GAROO SOLAR FARM AND BATTERY ENERGY STORAGE SYSTEM (SSD-79747209) TAMWORTH REGIONAL COUNCIL - SUBMISSION RESPONDING TO ENVIRONMENTAL IMPACT STATEMENT (EIS)

Ref: jk/SL DocSet ID 3196455

8 April 2026

DRAWING: Preliminary & Conceptual Creek Bridge Layout

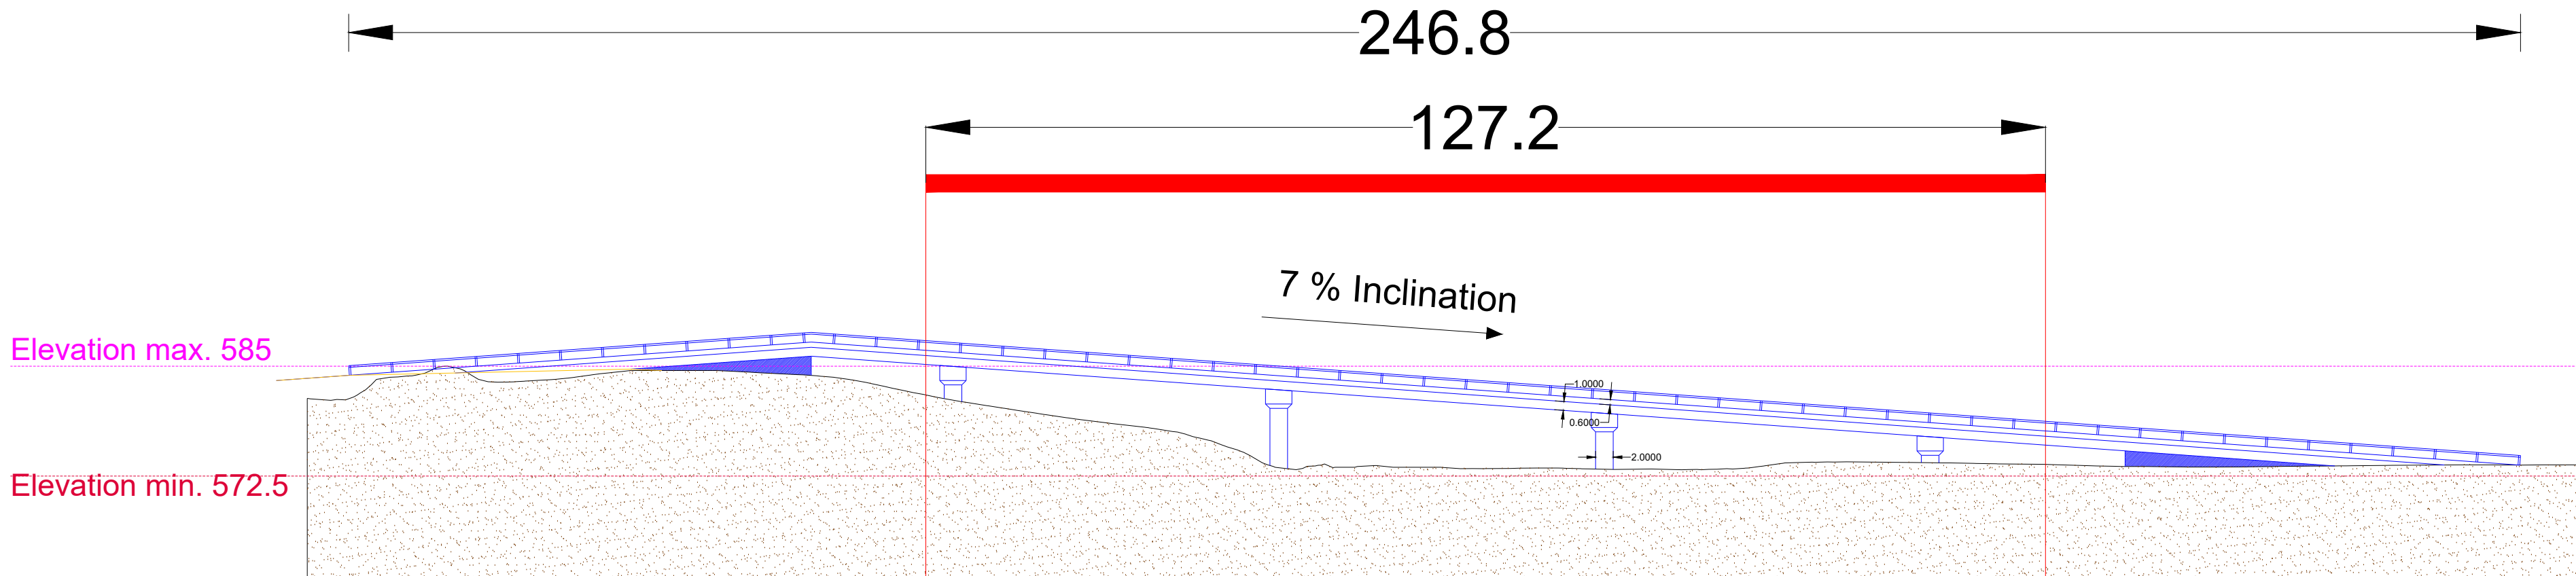
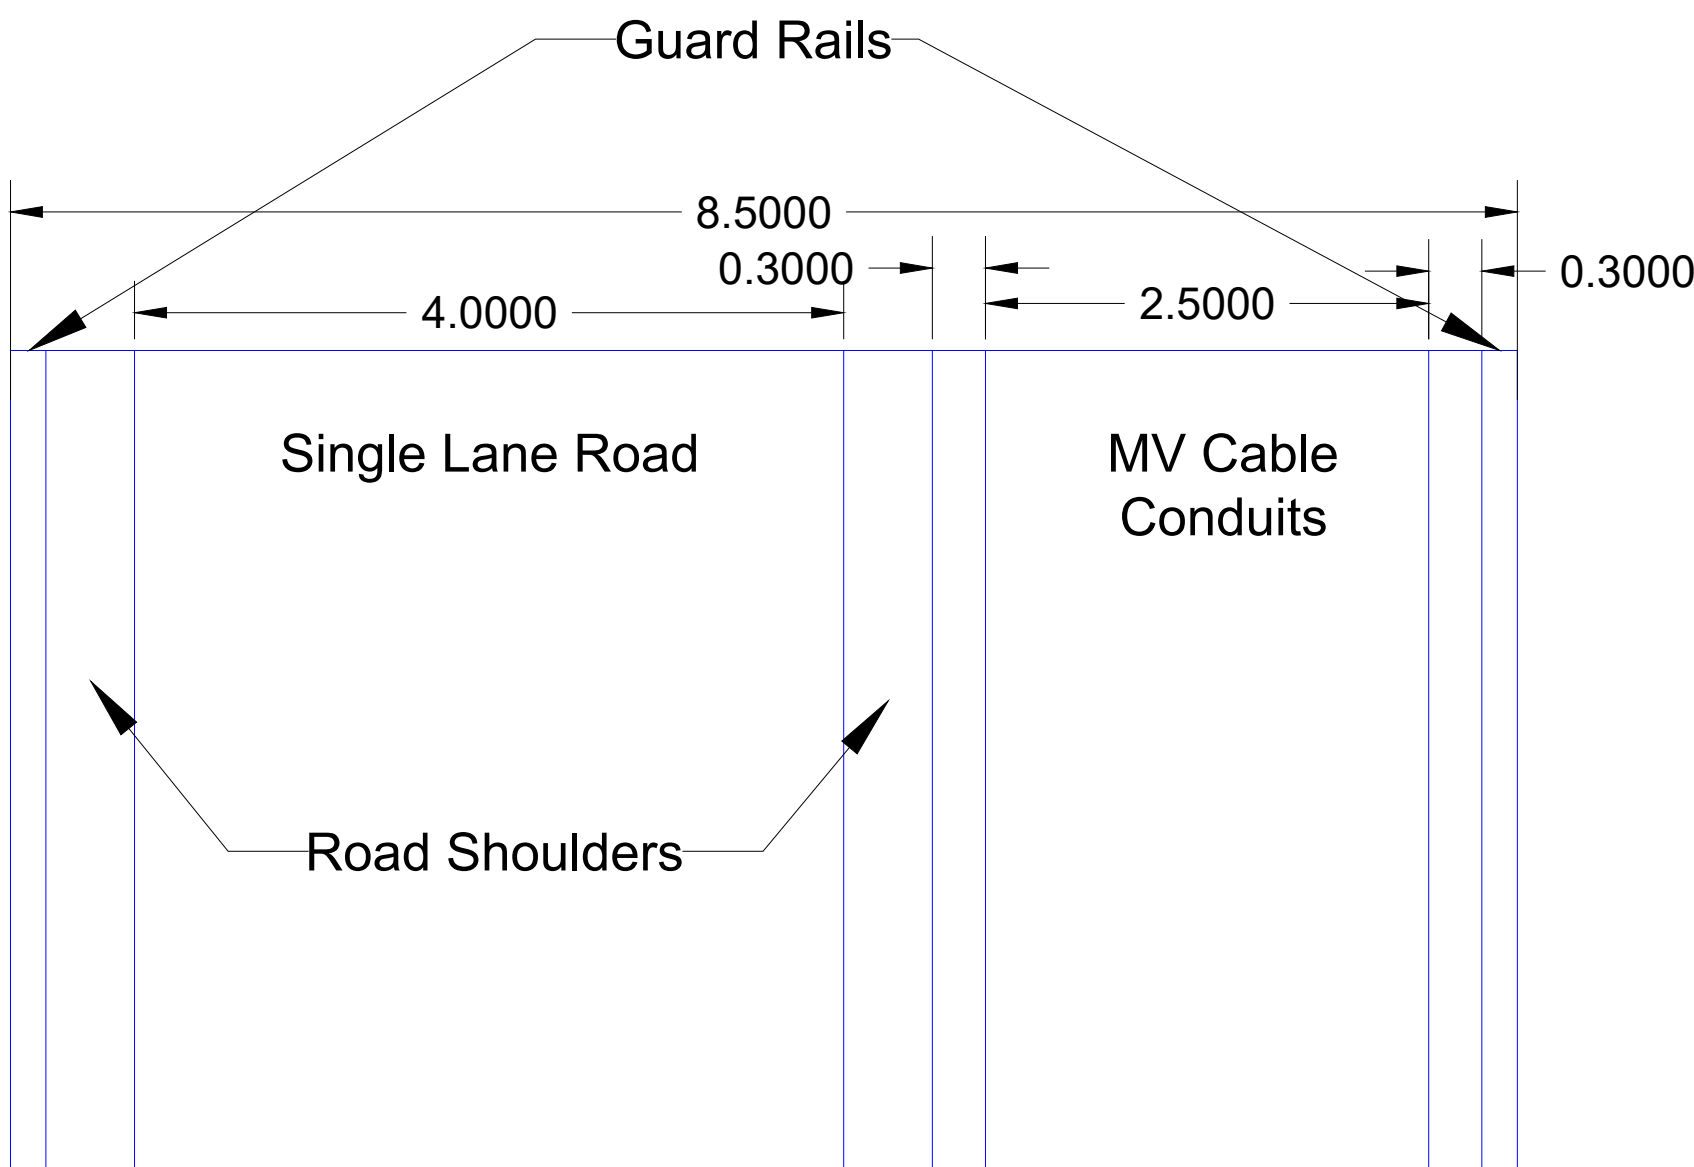
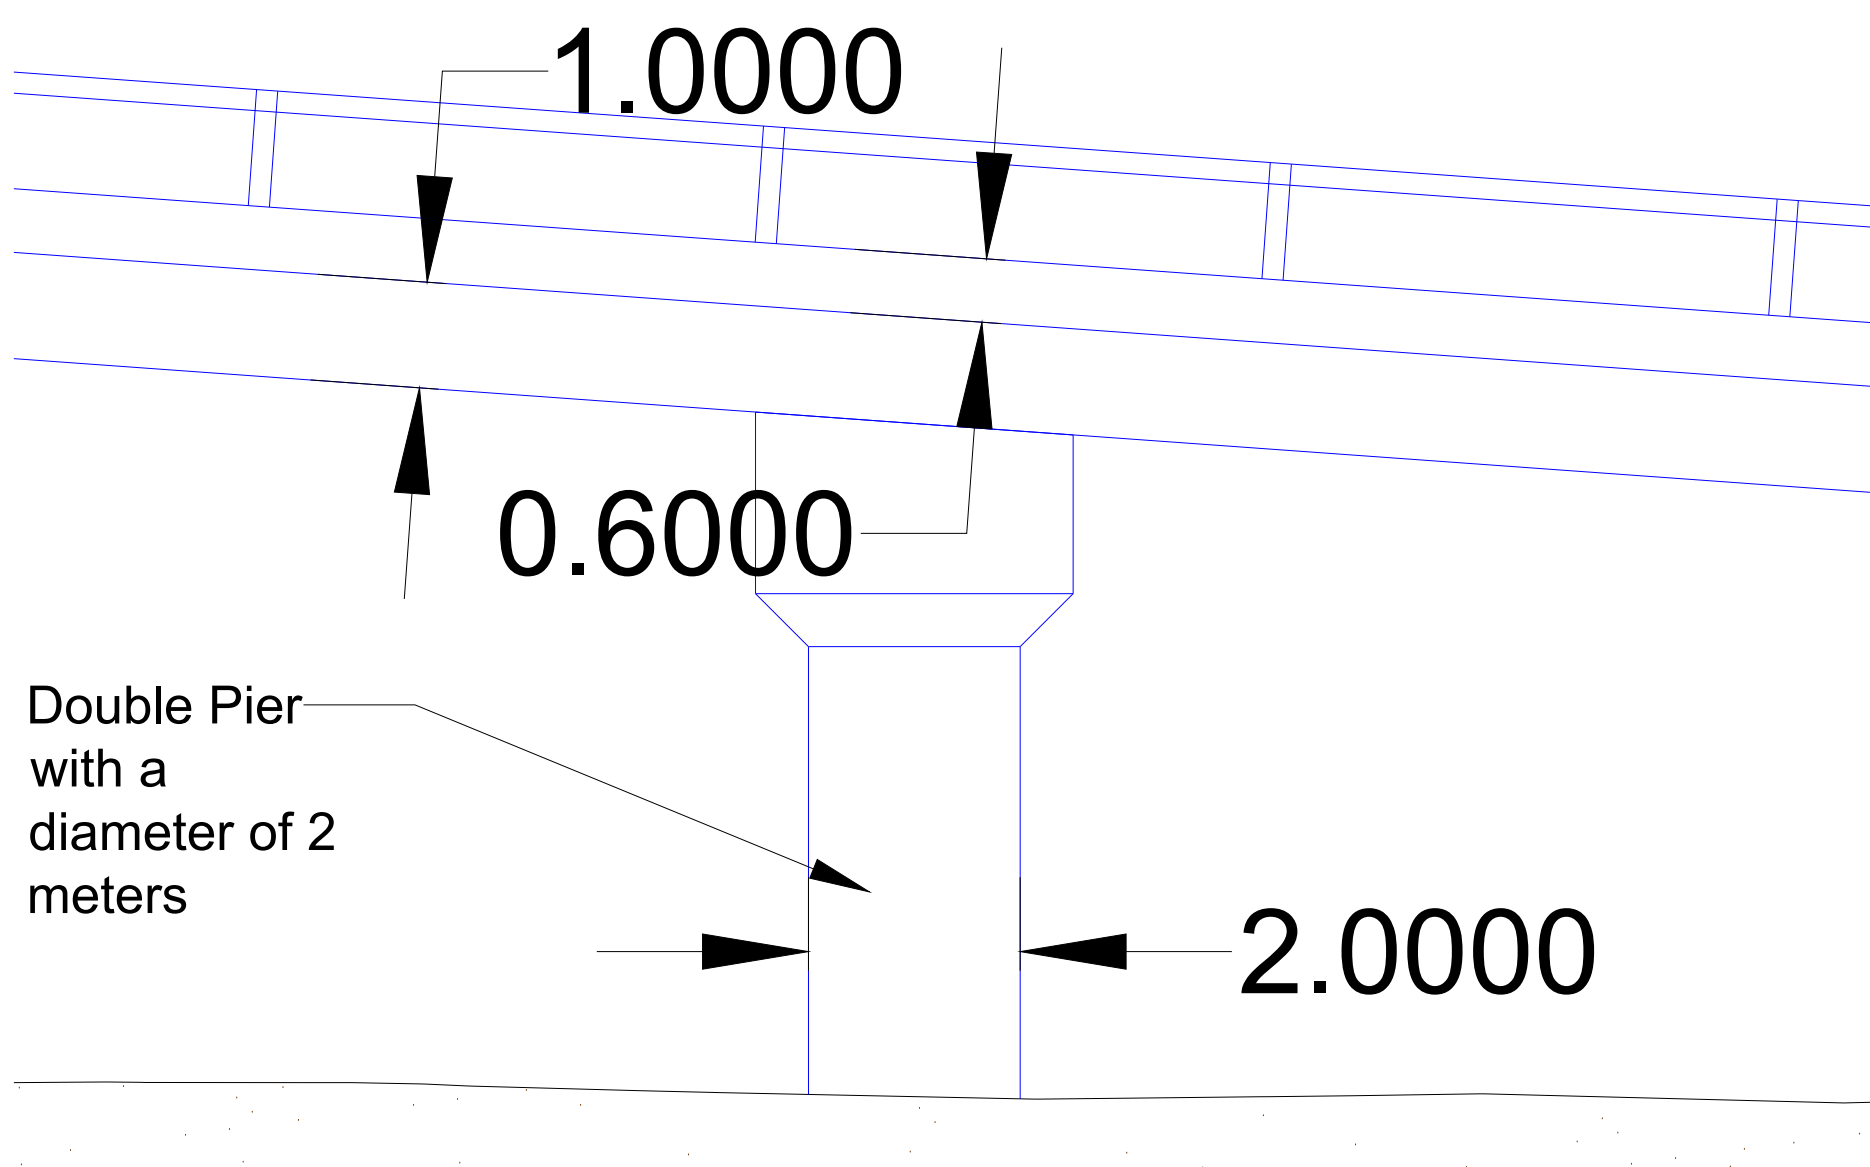
- Council requests further detail regarding the proposed bridge crossing of Tamarang Creek, including the precise location of bridge piers, construction methodology, extent of riparian vegetation disturbance, and specific mitigation measures to protect aquatic habitat during construction.

Garoo Solar Farm And BESS
Garoo Road, Garoo
Site Access Strategic Design

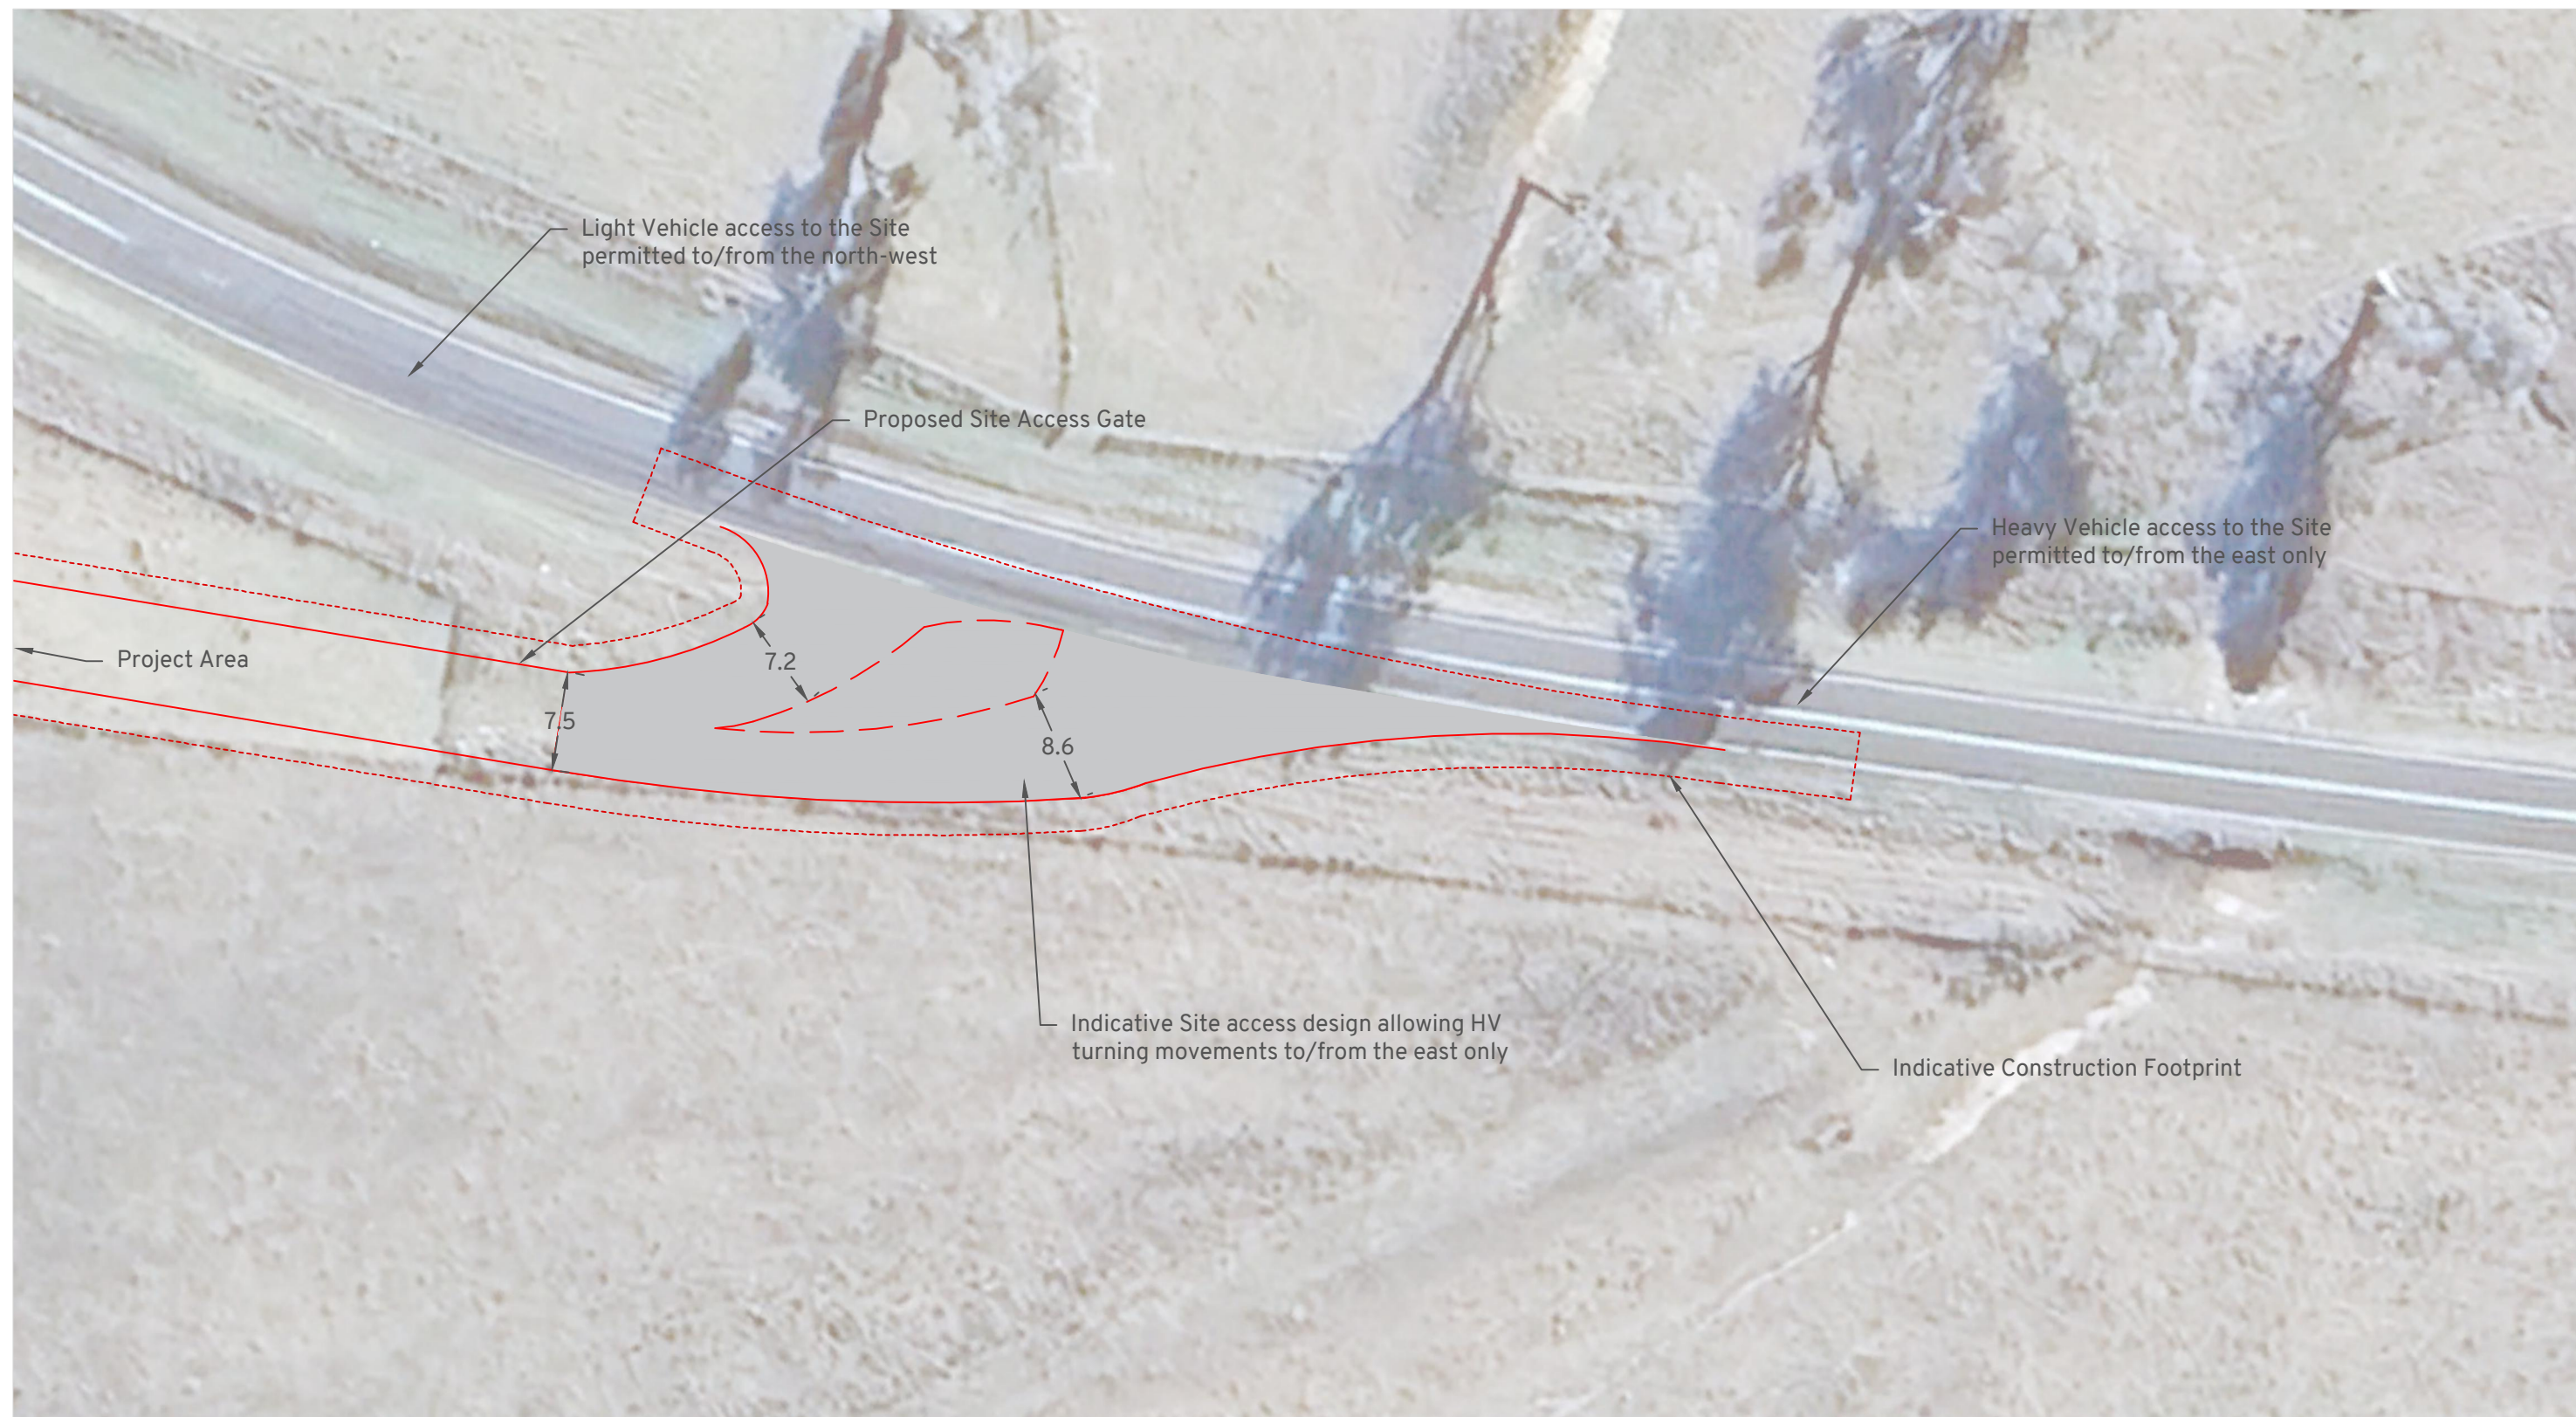
- Council remains concerned about the location and configuration of the proposed site access from Garoo Road. In particular, the access appears to be located on or near a curve, raising questions around available sight distance and the ability for vehicles to safely enter and exit the site without “straight-lining” movements across the carriageway.
- Council considers that the final design should demonstrate adequate safe stopping sight distance and confirm that vehicle turning paths can be accommodated safely and efficiently under peak construction traffic conditions.

- Council seeks further justification of the proposed Garoo Road site access intersection treatment. While a Basic Left Turn may be suitable where left-turn volumes are low, Council considers a Channelised Right Turn may be more appropriate if the access carries higher traffic volumes or the dominant turning movement during construction. The final treatment should be confirmed based on traffic volumes, turning movements, approach speeds, sight distance and overall road safety.
